Alan Cadogan - MP 09_0066 MOD 6 - Chatswood Albert Ave/Thomas St Development Concerns

From: "Loveday, Mike, Vodafone Group" <mike.loveday@vodafone.com>
To: <alan.cadogan@planning.nsw.gov.au>
Date: 2/05/2013 4:45 PM
Subject: MP 09_0066 MOD 6 - Chatswood Albert Ave/Thomas St Development Concerns

COMPARABLE
HEIGHT STUDY
A-0201
SECTION 75W MODIFICATION 6

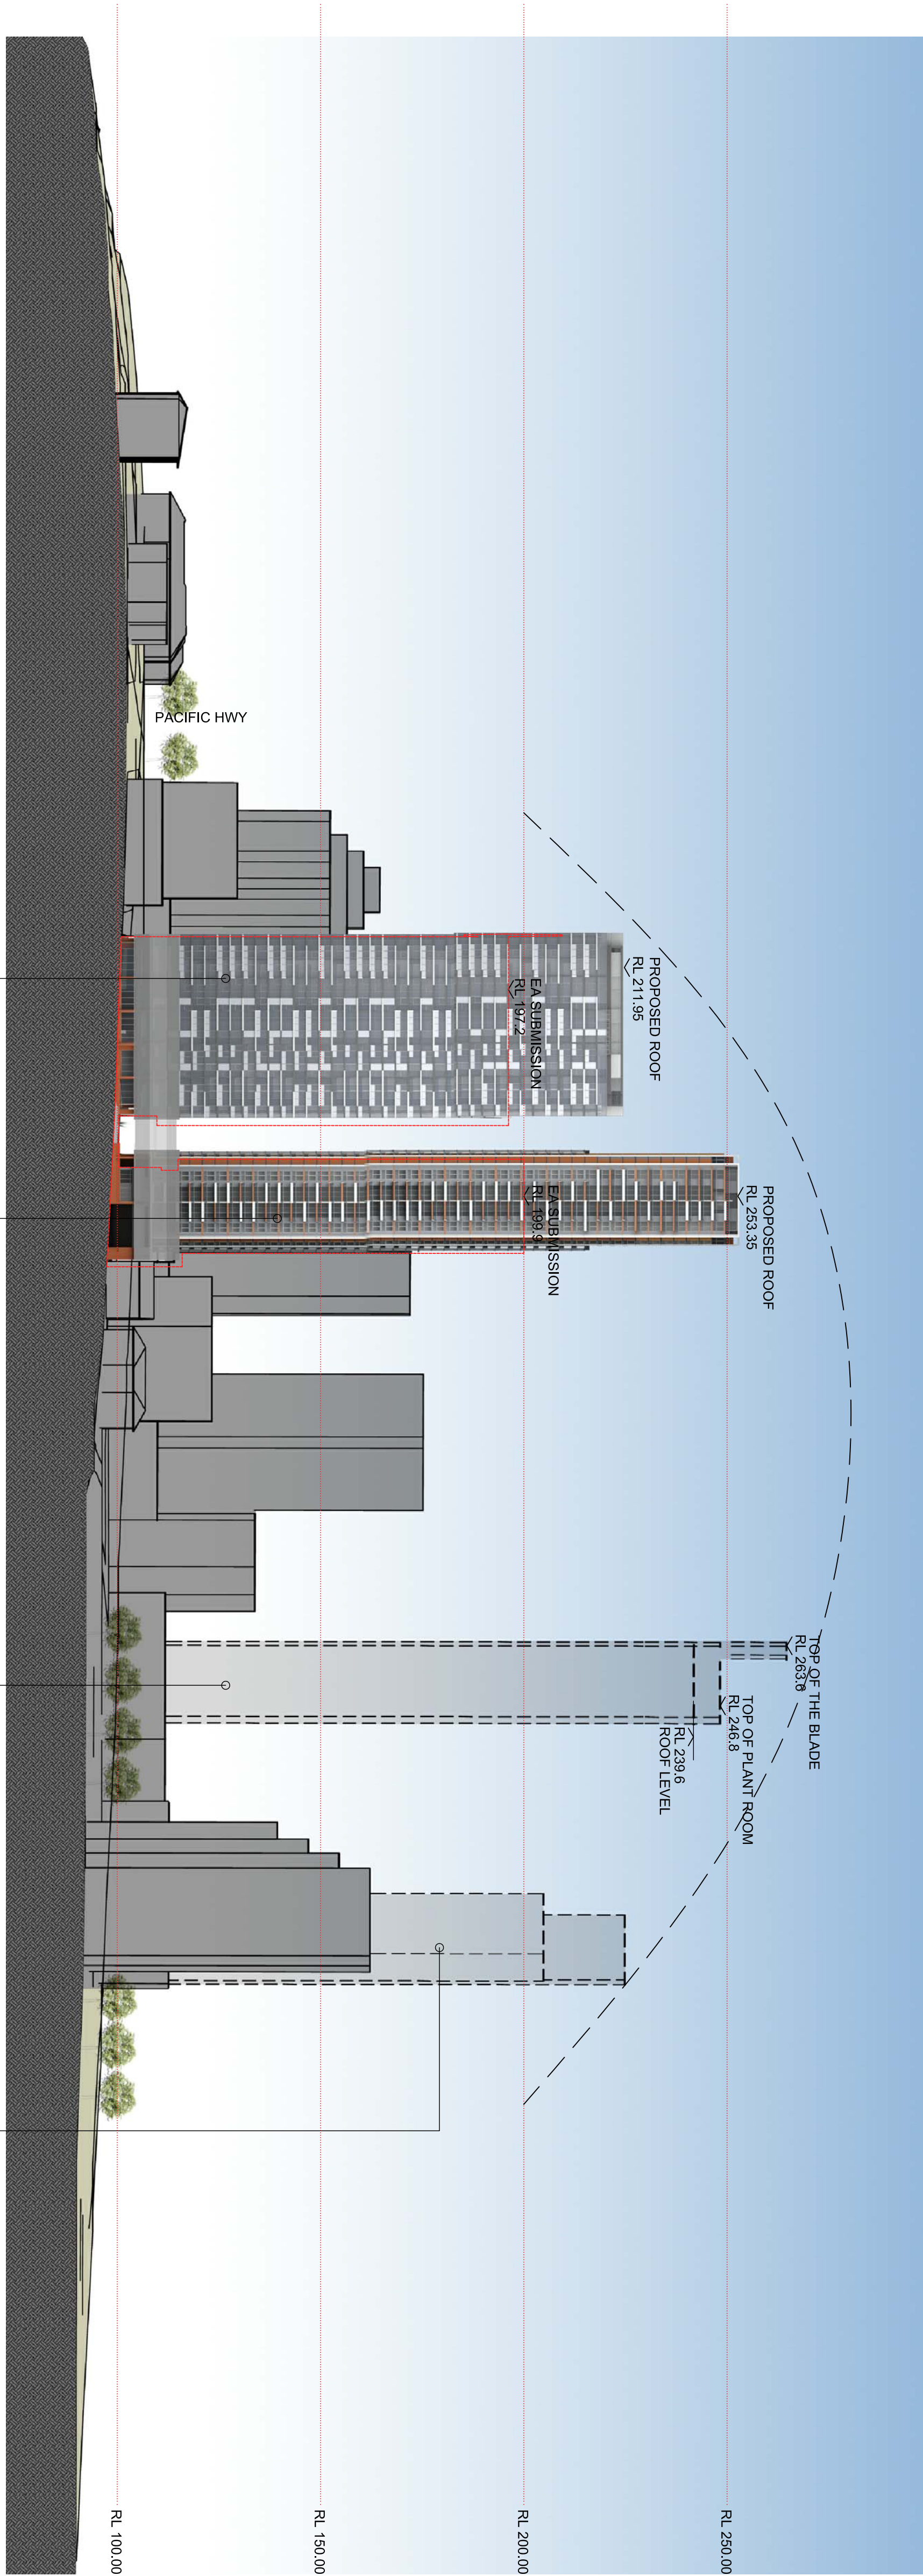
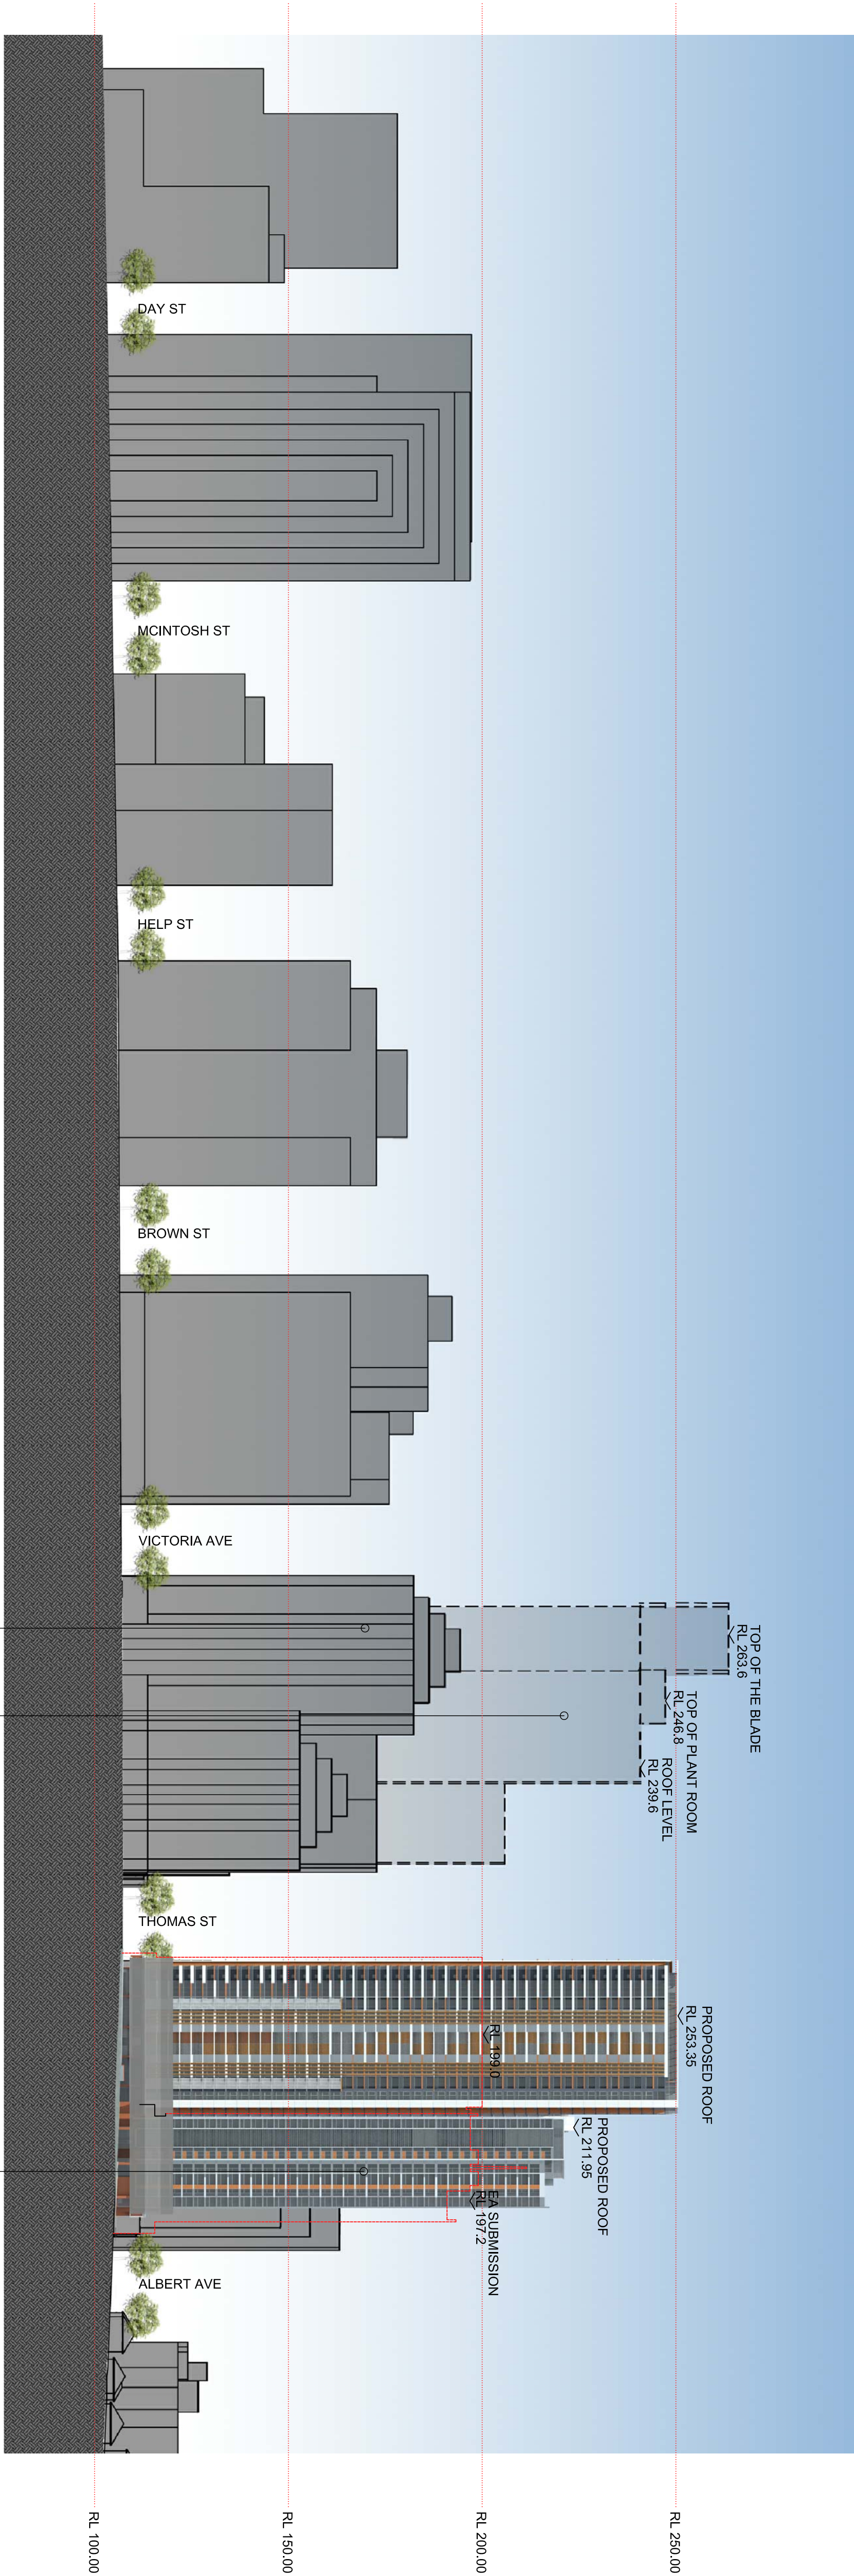
Tower-2 with a proposed height of 222M would bring this close to the height of Meriton World Square, today the tallest residential building in Sydney located in the centre of Sydney CBD. Tower-1 would become the tallest building in Sydney at 253M, surpassing even Citigroup Tower at 2 Park St in the Sydney CBD holding the current record 243M (international standard of the Council on Tall Buildings and Urban Habitat). The height of both towers especially Tower-2 (given the bulk form of the rectangular profile) is completely inappropriate 11kms north of the Sydney CBD in a residential fringe area on the edge of Chatswood, bordering residential buildings only 8 and 3-4 stories high.
